PLANNING DEPARTMENT – Development Review Services

May 5, 2014

**RE: Warehouse Addition -2655 Baylor Drive SE
Grading & Drainage Plan
Engineer's Stamp Date 4-28-2014 (File: M16D006)**

DRAINAGE PLAN

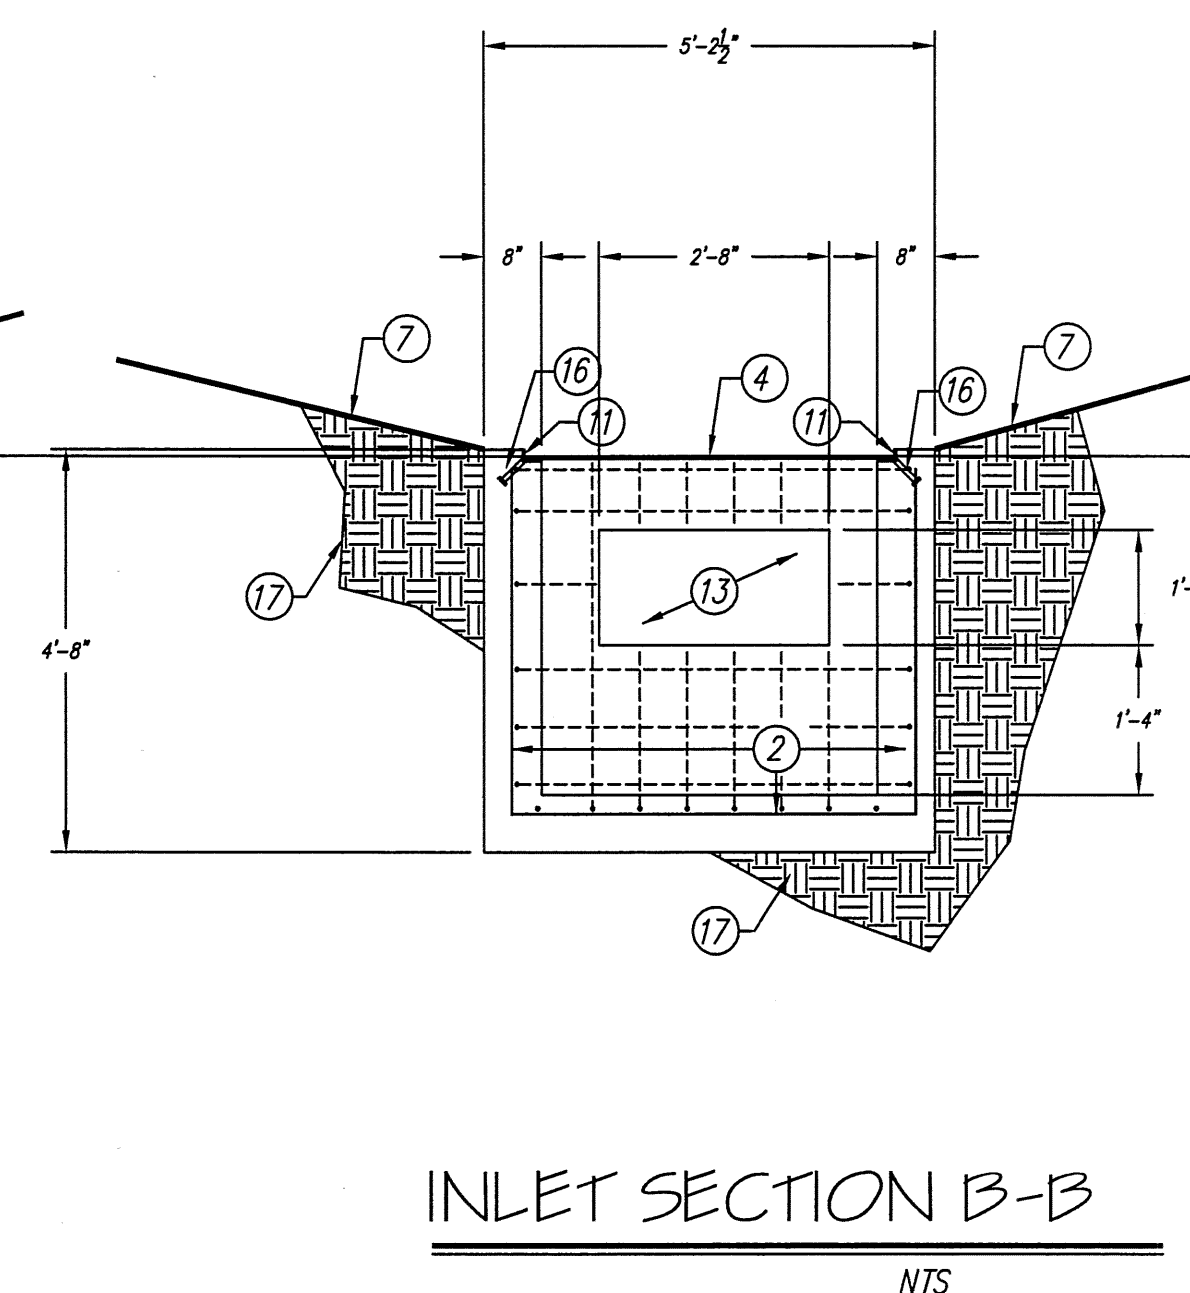
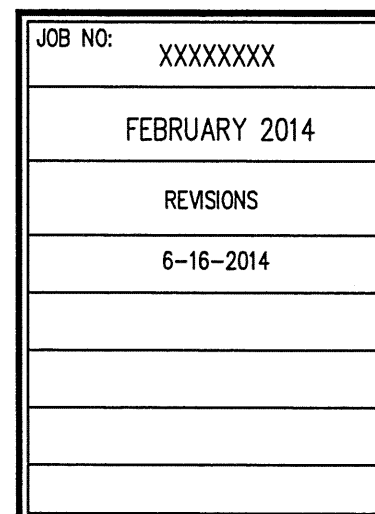
- 1) Our records indicate a 21" Storm Drain runs underneath the proposed building. A comment by Hydrology Section addressed this in a comment during the DRB hearing (DRB # 1010051).
- 2) The calculated [existing conditions] runoff volume historically flowed into property to the west. With the retaining wall in place no portion of the proposed development will flow westward. Therefore the entire proposed runoff volume must be accounted for in the ponding – or 3091cfs, rather than the difference between the proposed and existing conditions.
